28 July 2023

Our Ref: R/2020/14/C and R/2016/20/F
File No: 2023/436112
Your Ref: SSD-9978934 and SSD 7684 MOD 1

Response to Submissions – Cockle Bay Park Redevelopment – Modification to Stage 1 (SSD 7684 Mod 1) and Stage 2 (SSD-9978934)

Figure 5: Measurement locations with comfort/safety classifications

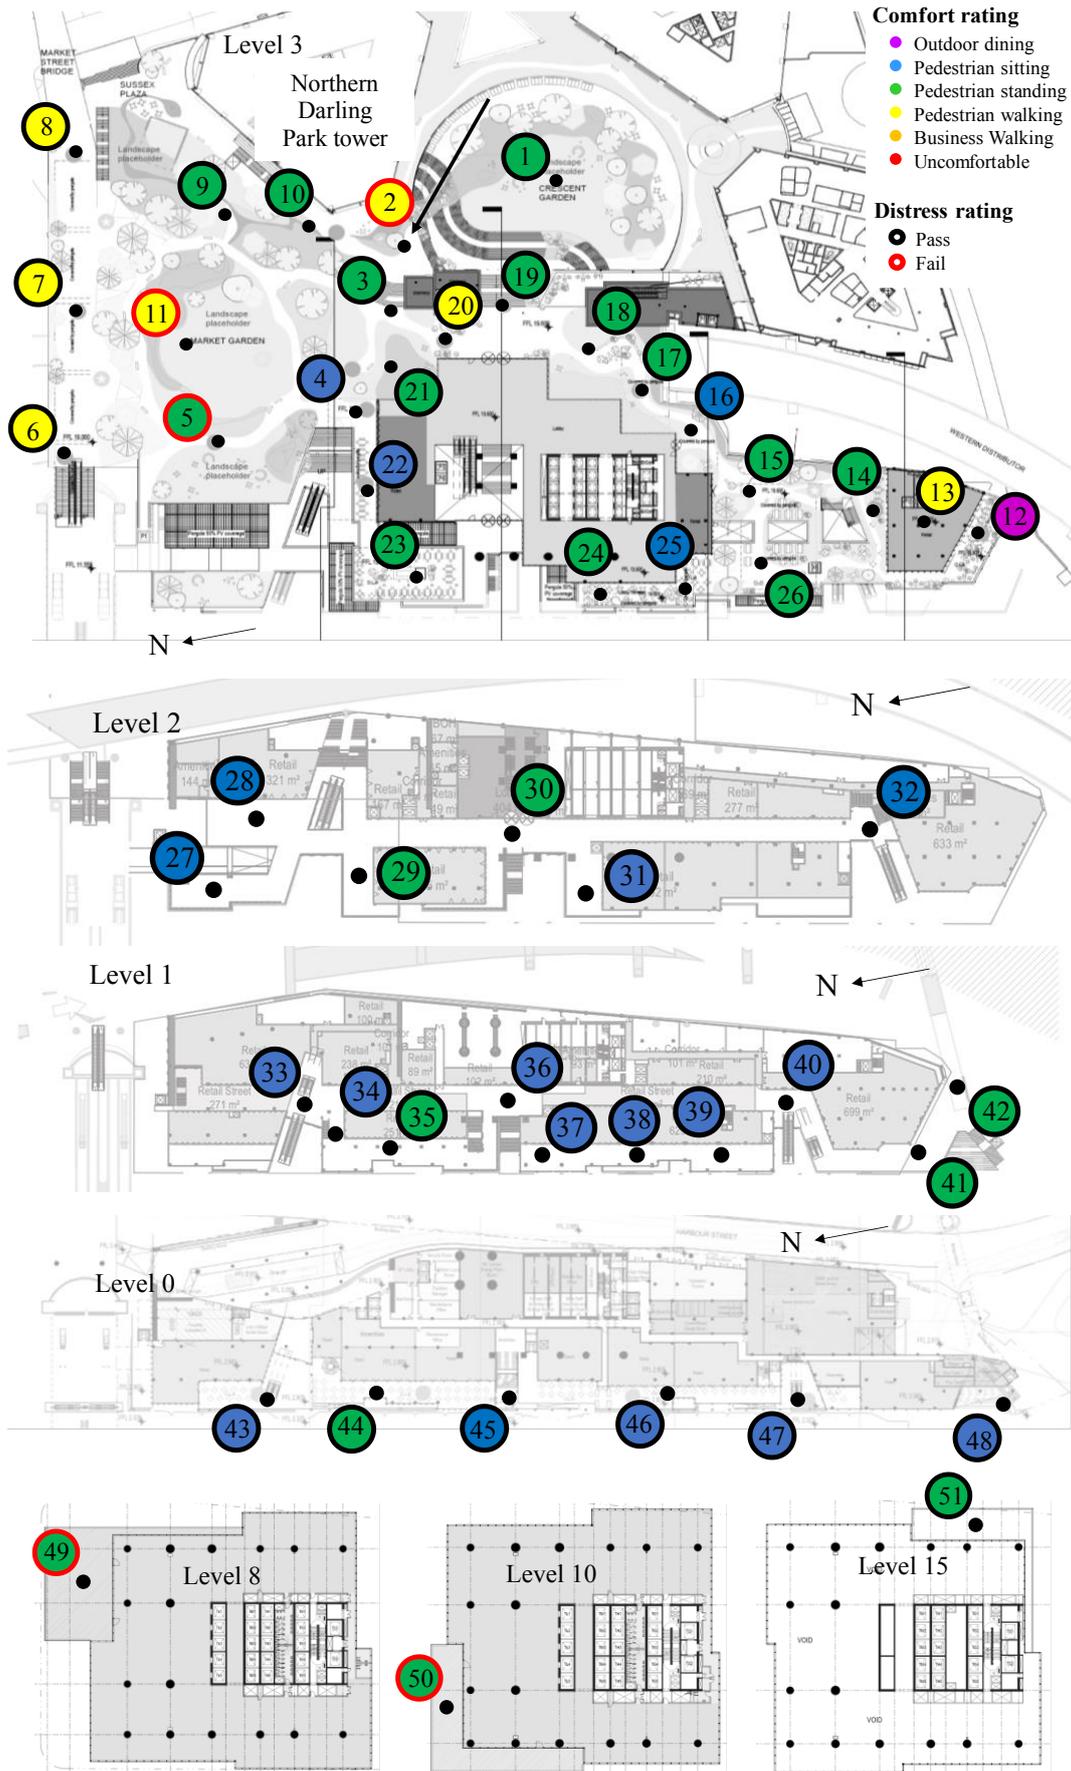
Our position remains that even 24m/s is considered unsafe in practice and as noted in our comments on the EIS, can be described as dangerous conditions for abled bodied people, and even more so for children and the elderly. We therefore maintain our position that we do not accept the safety criterion proposed by ARUP of 28m/s.

Appendix F – Wind Memo prepared by Arup has been reviewed. It remains unclear whether the local treatments described in the previous RtS package are still required and no further details of these treatments (such as a pooling water feature or vertical balustrade) have been provided. We reiterate that retrofitting these features is too late in the process and must be considered in the assessment of the Detailed DA.

- It is noted that the City remains significantly concerned about the wind impacts within this development and the adverse impact this will have on the quality, safety and amenity of the public space being delivered. We do not agree with the safety criterion proposed of 28m/s.
- If the Department is supportive of the wind conditions and comfort criteria proposed, at a minimum any wind mitigation measures must be clearly identified and shown on the drawings for assessment *prior to determination*.

## Podium North

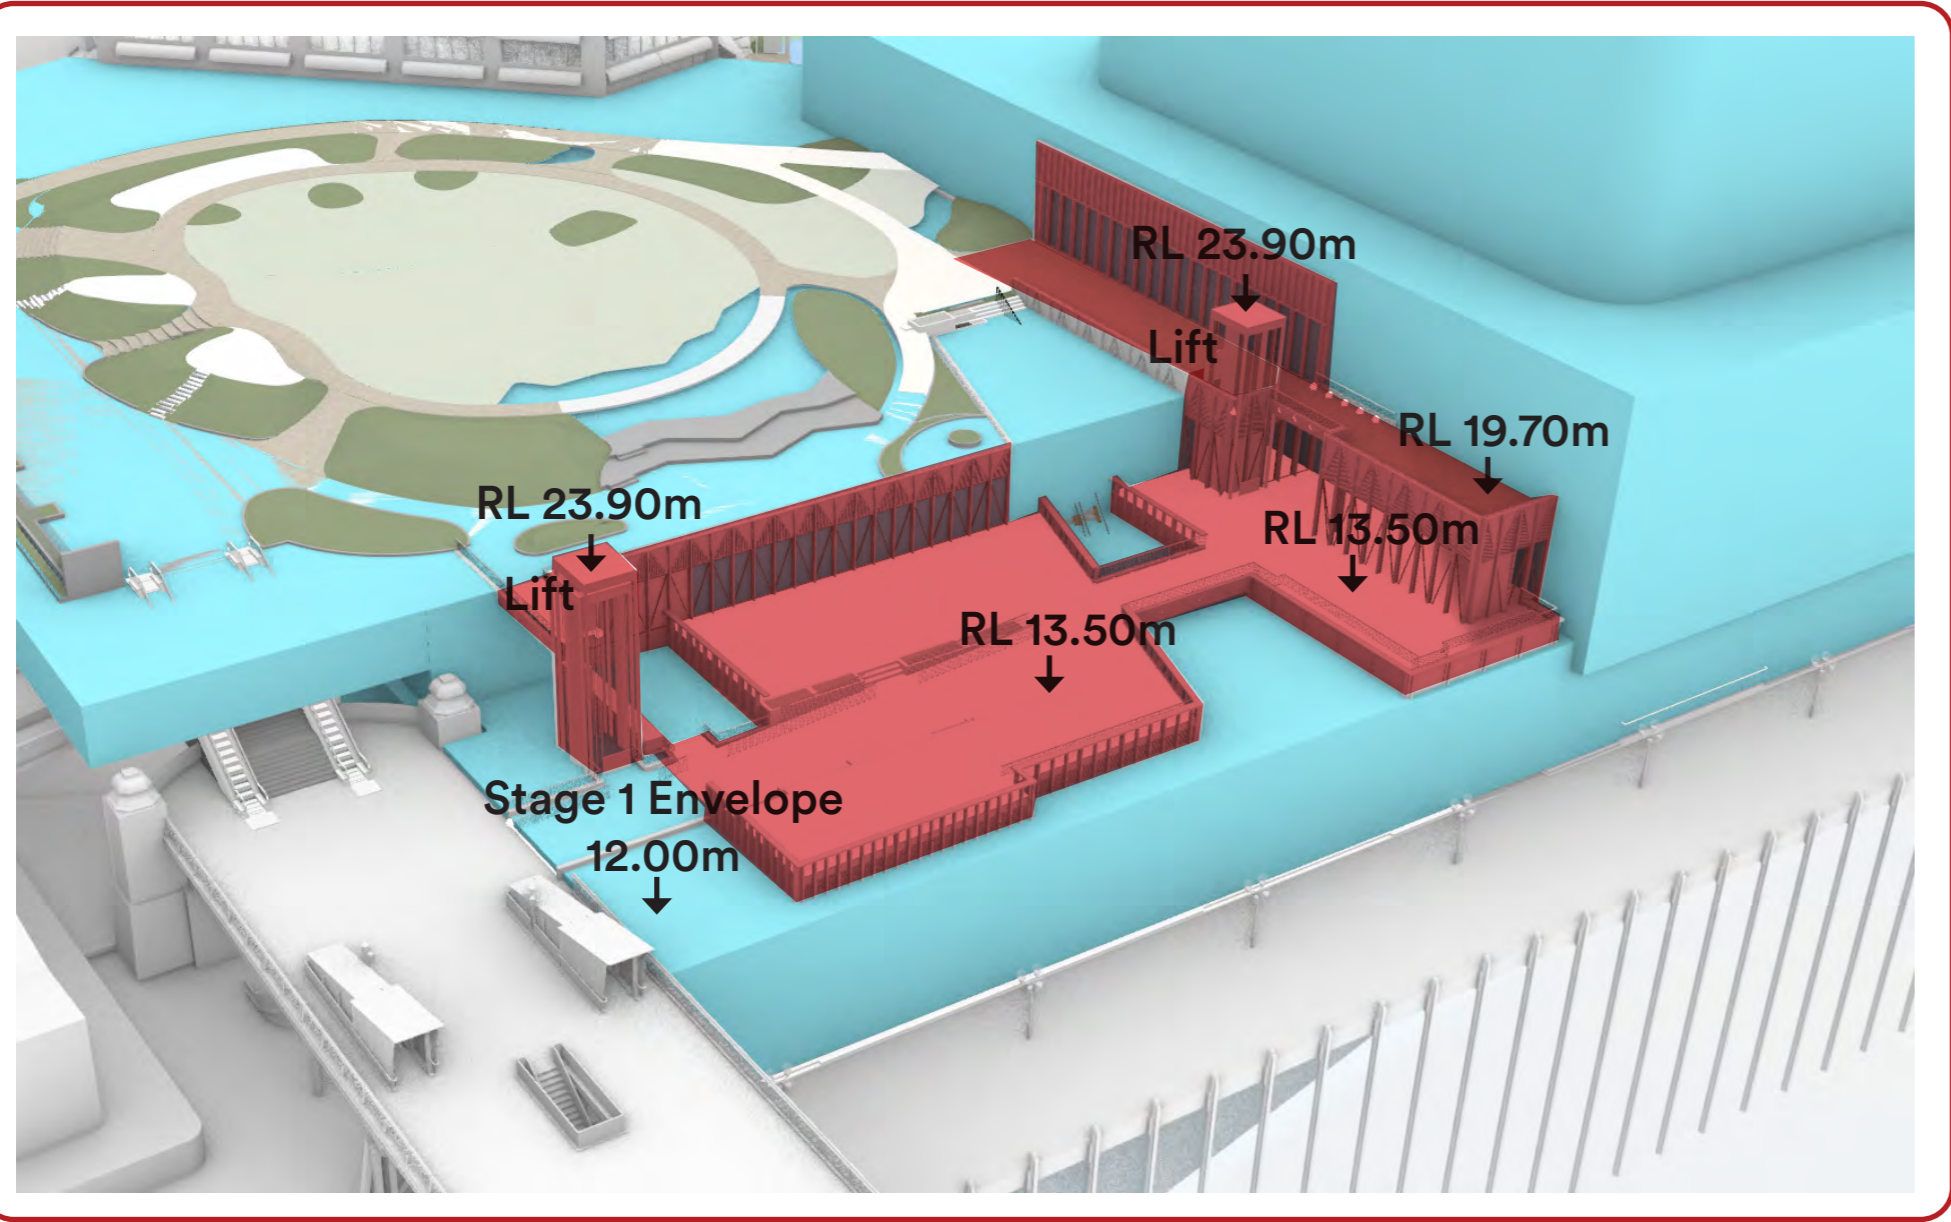
The City has previously raised concern about the visual and physical impacts of the north-western corner of the double storey podium on south-westerly sightlines from Pyrmont Bridge (point 2.1 of our previous letter).

The north-western corner of the podium exceeds the RL 12m of the approved podium envelope. In justifying the additional height, the *Mod 1 Submission and Amendment Report* suggests that the envelope increase is to accommodate additional retail space and to provide better access to the open space above the podium.

It is our position that the comparison images at Figure 20 COS5 in the *Supplementary Design Report* highlight that the top of the podium's north-western corner does

negatively block views towards the harbour water and the convention centre. This obstruction is considered inappropriate, given the views from Pymont Bridge are properly protected by other recent developments in the bridge's vicinity. Maintaining the approved RL 12m at this corner could only have marginal impact on the yield of retail space and would have no impact on public accessibility if the podium corner is properly designed.

- The additional height on the north-western corner of the podium is not supported by the City. The approved height established in the Concept envelope should be maintained.

# Pymont Bridge connection

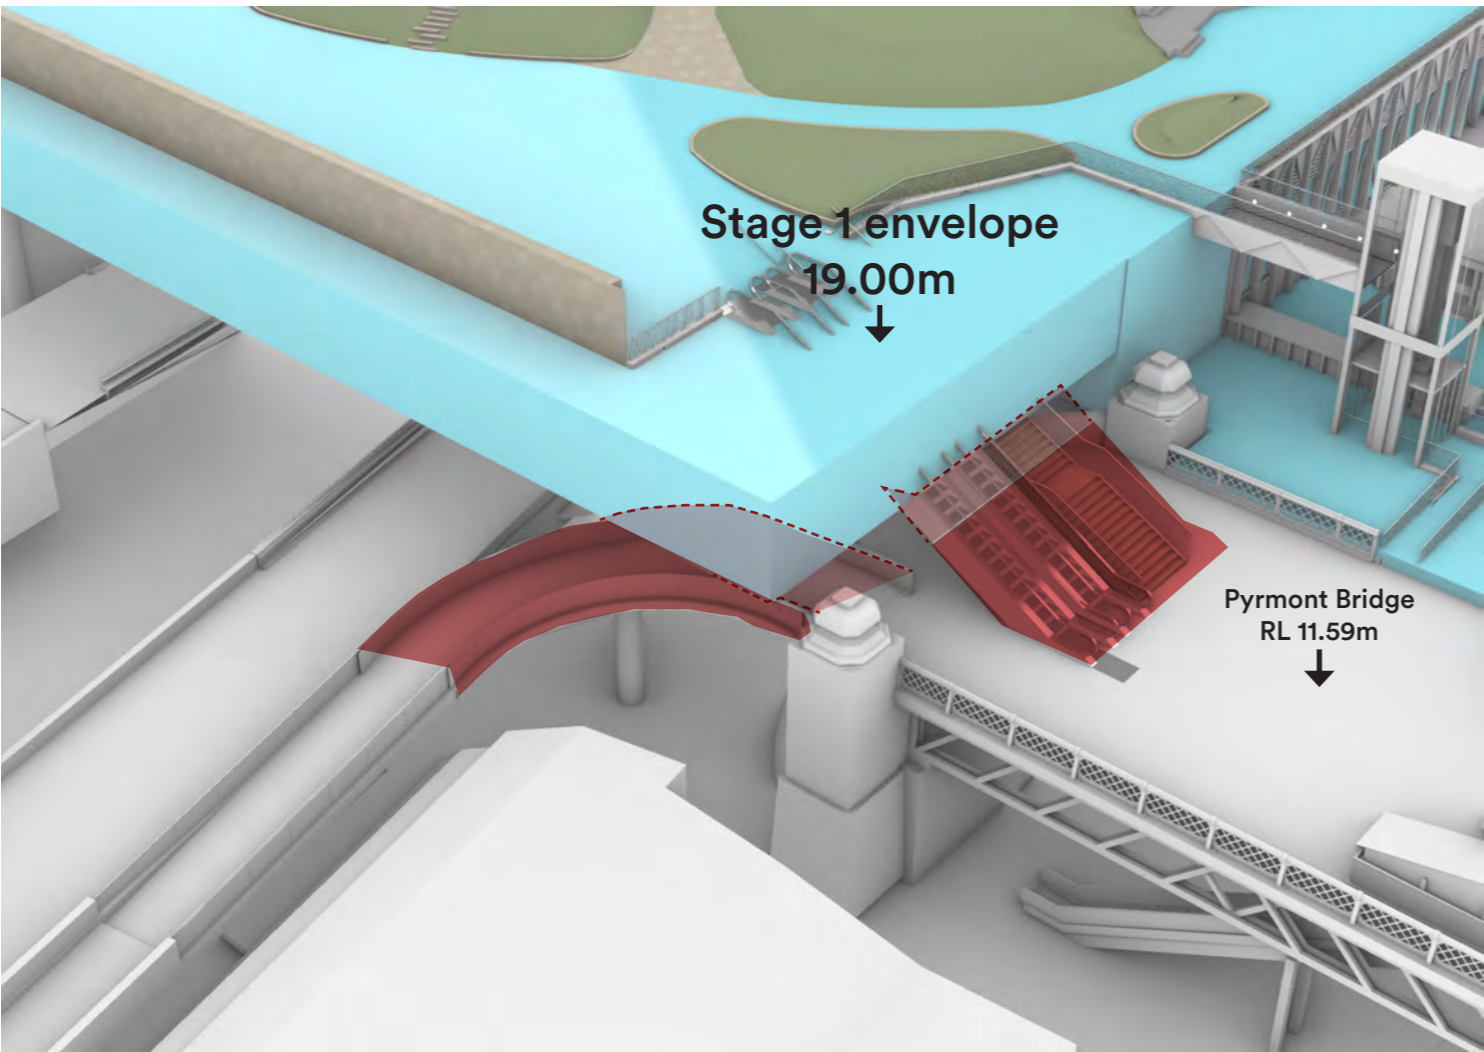
The proponent has suggested using rumble strips to slow cyclists down on approach to the King Street Bridge entrance from Pyrmont Bridge. It is requested that the City be consulted if this treatment is proposed.

- The City should be consulted on the proposed rumble strips proposed and this should be a requirement of any condition of consent on this matter.
- The number of loading spaces is inadequate and remains unsupported by the City.
- Conditions of consent relating to transport and access can be provided to the Department when required.

# Market Street Bridge connection

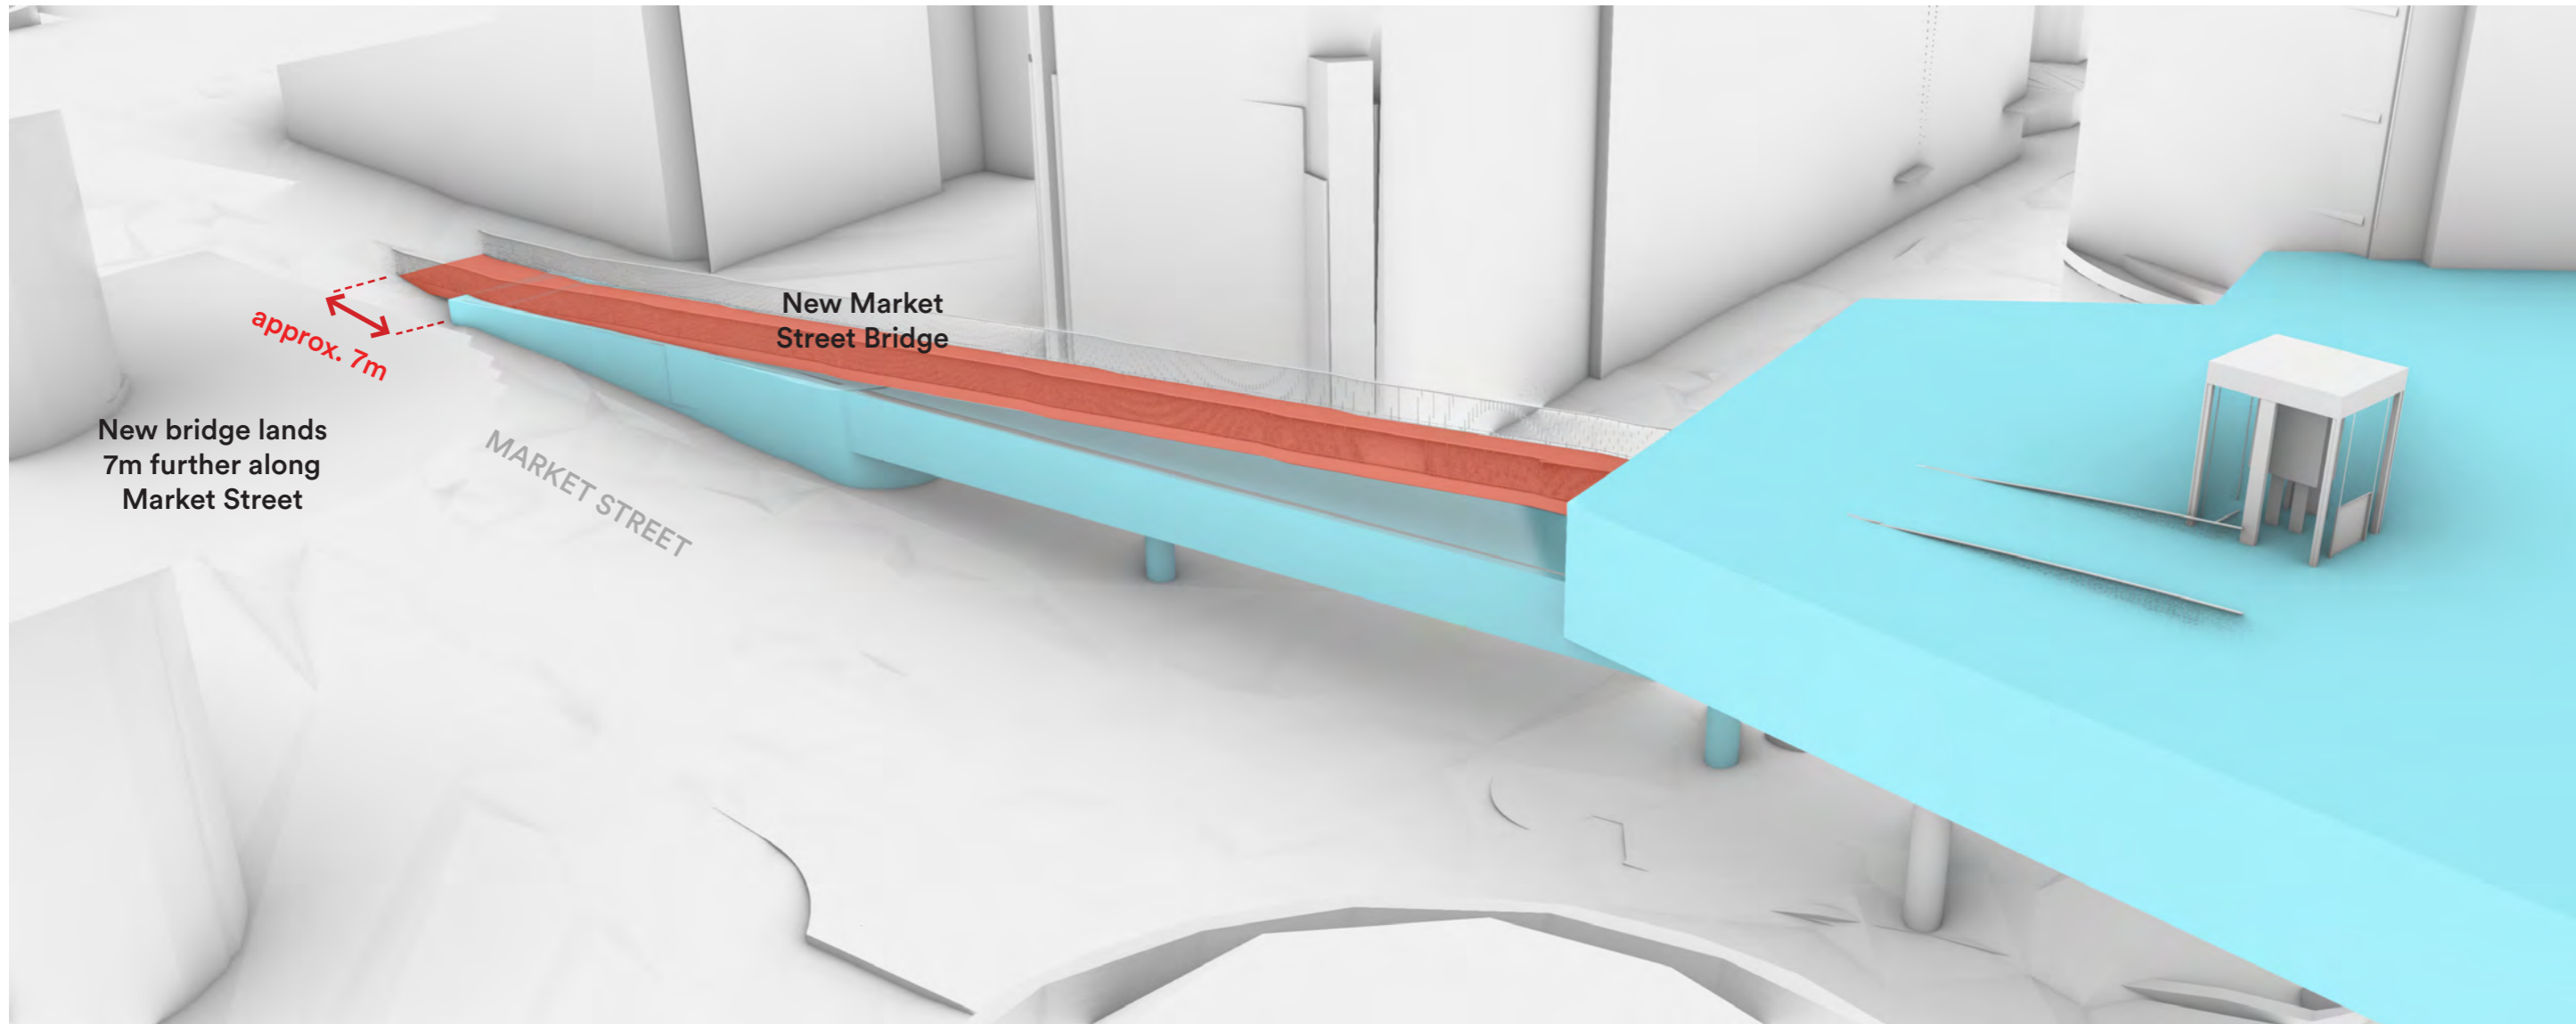
It is understood that the ramp needs to be longer to provide a more accessible slope. The Department should ensure that impacted trees/ telephone booths are adequately considered and resolved in the assessment.

Regarding the height of the ramp, the RtS says that the height increase *"is attributable to minor adjustments to the ramping configuration to accommodate the more accessible gradient."* This is not clear and has not been further demonstrated or explained. It would be expected that the increased height would make it more difficult to achieve the required grades.

- Consideration should be given to the impacted trees/ telephone booths in the assessment or by condition of consent.

- The Department should ensure that the reason for the height increase of the ramp is clearly demonstrated and properly understood.
